Application No: Y/151/20/PL
Site Address: Pollards Nursery Lake Lane Barnham PO22 0AD
Description of works: Permanent siting of temporary seasonal horticultural worker accommodation (8 mobile homes & 3 retrospective mobile homes), hardstanding & service building. This site also lies within the parish of Barnham, is in CIL Zone 3 (Zero Rated) as other development.

Thank you for your internet representation made on 6th February 2021 which has been recorded as an objection with the comments as follows:

Scheme **Eric Wall Nursery, Lake Lane, Barnham, PO22 0AD**
Title **Proposed Site Plan (2 of 2)**

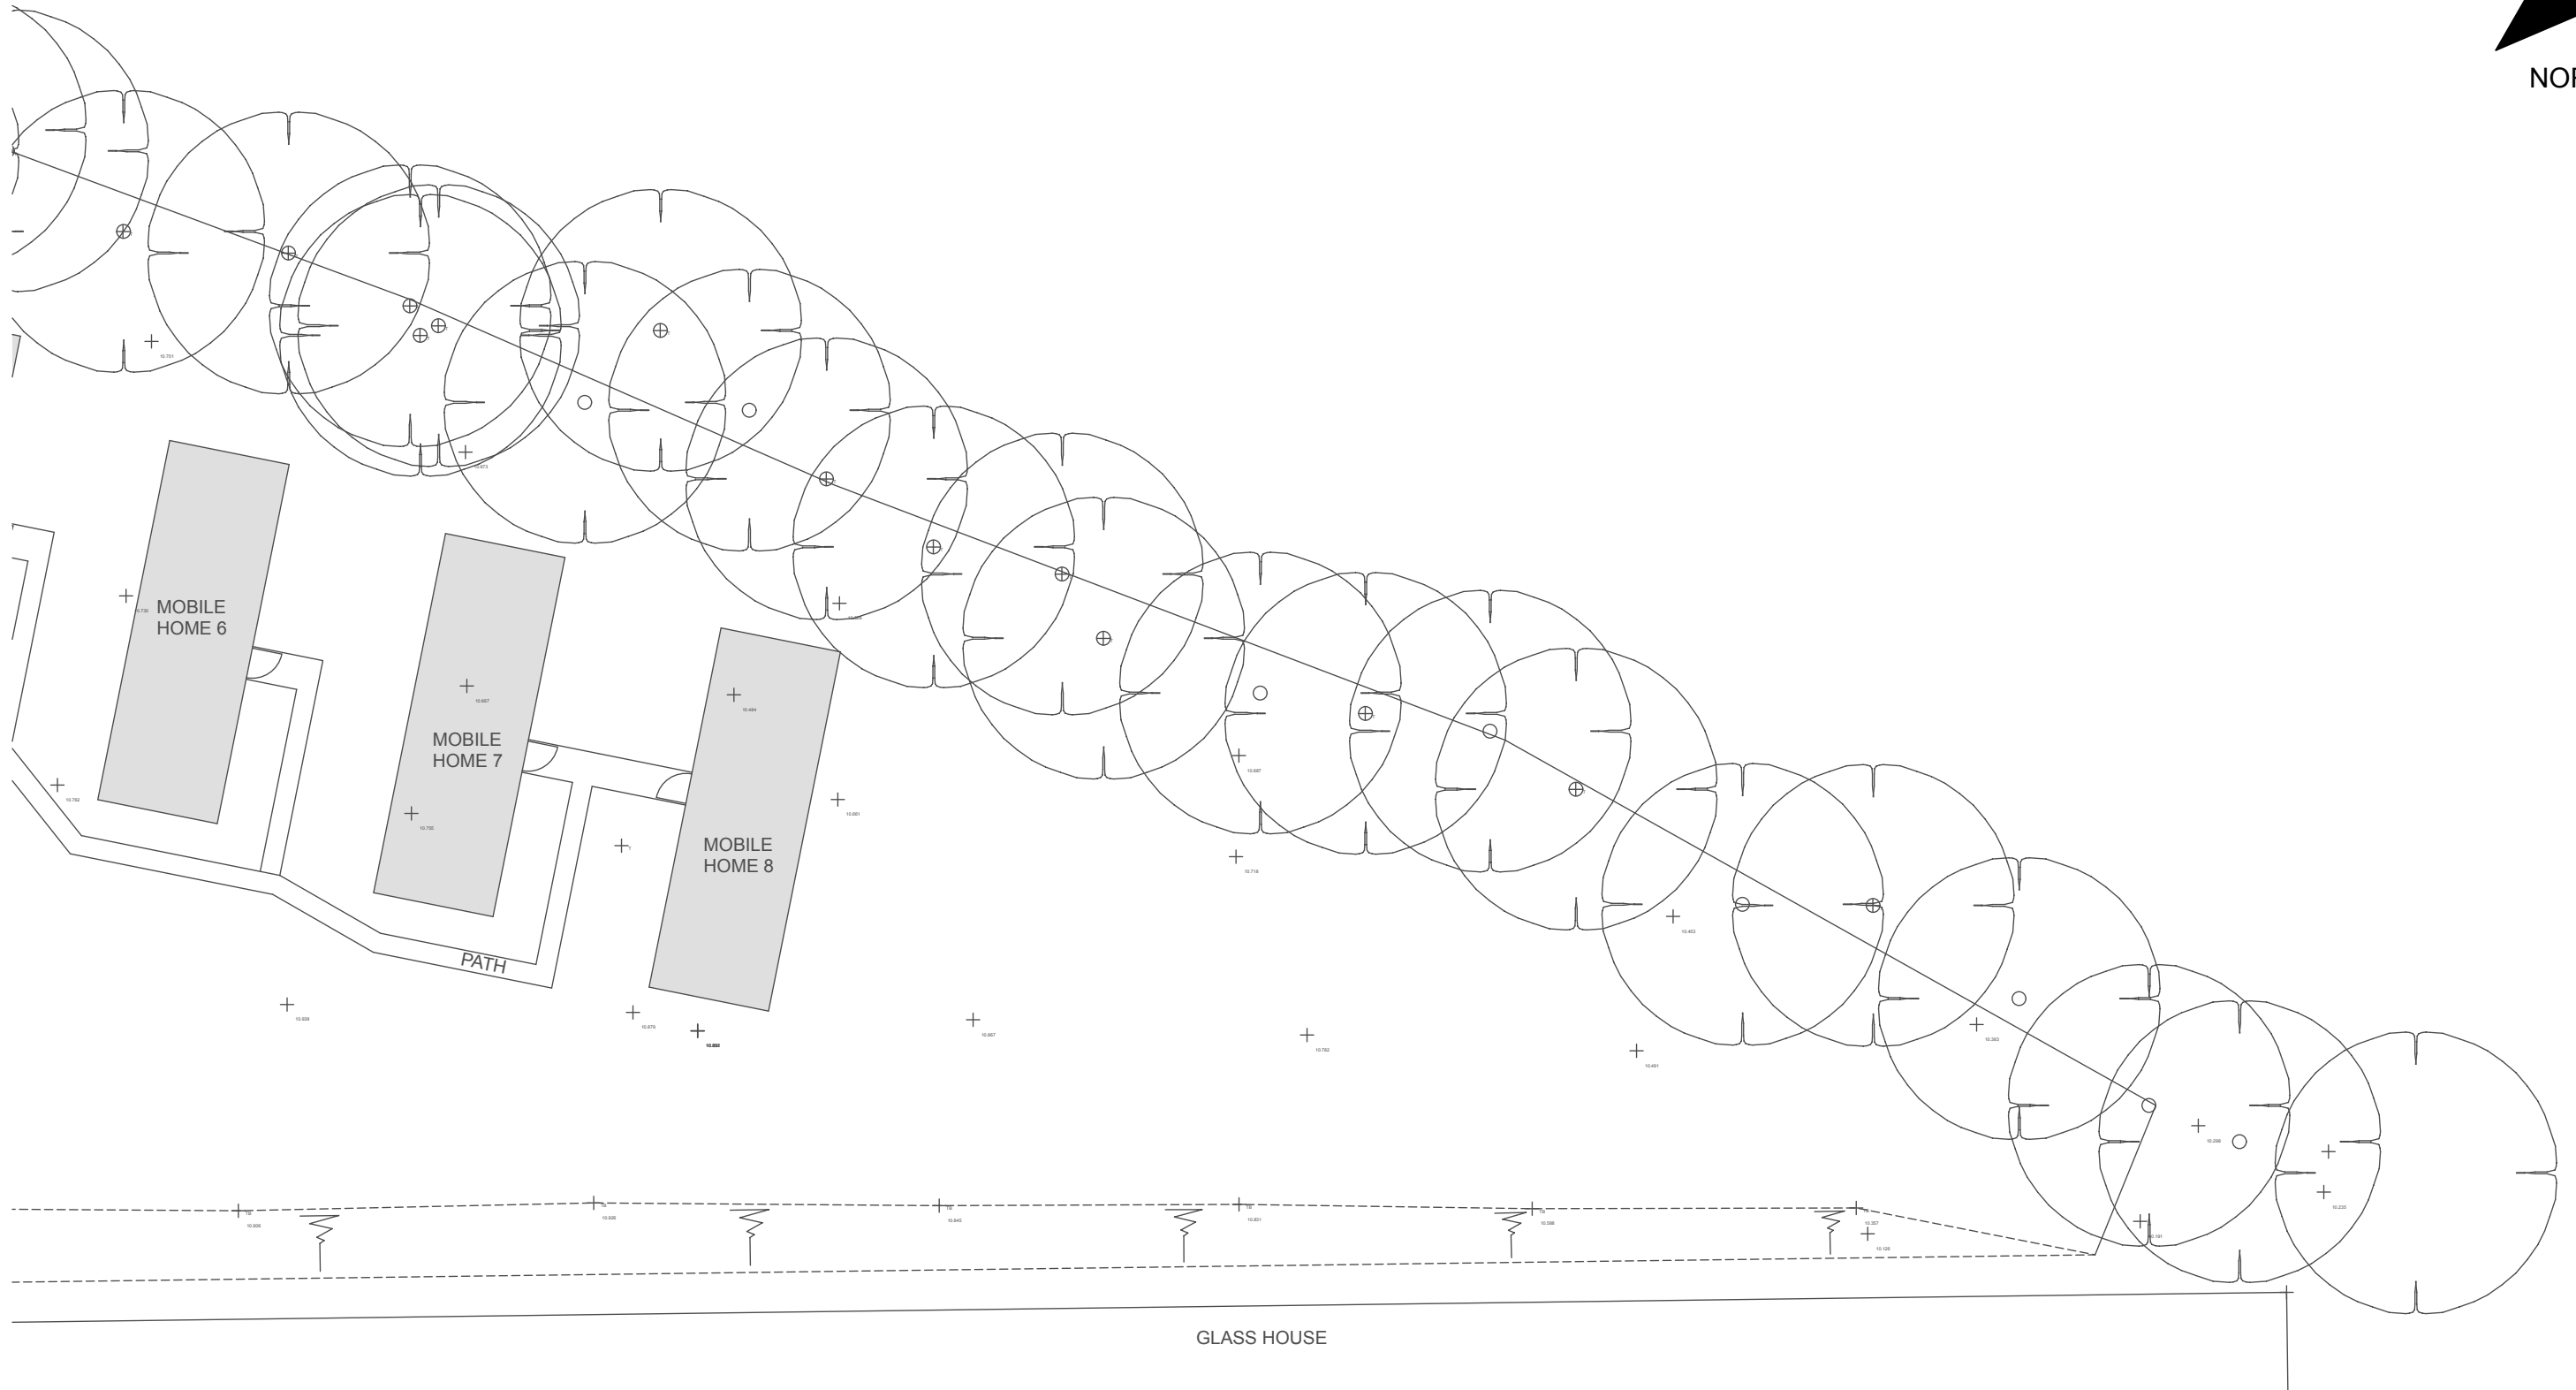
There does not appear to be any vehicular access to the site of the 8 mobile homes. Surely this is not acceptable. What provision is there for emergency services access, removal of waste, also foul drainage?
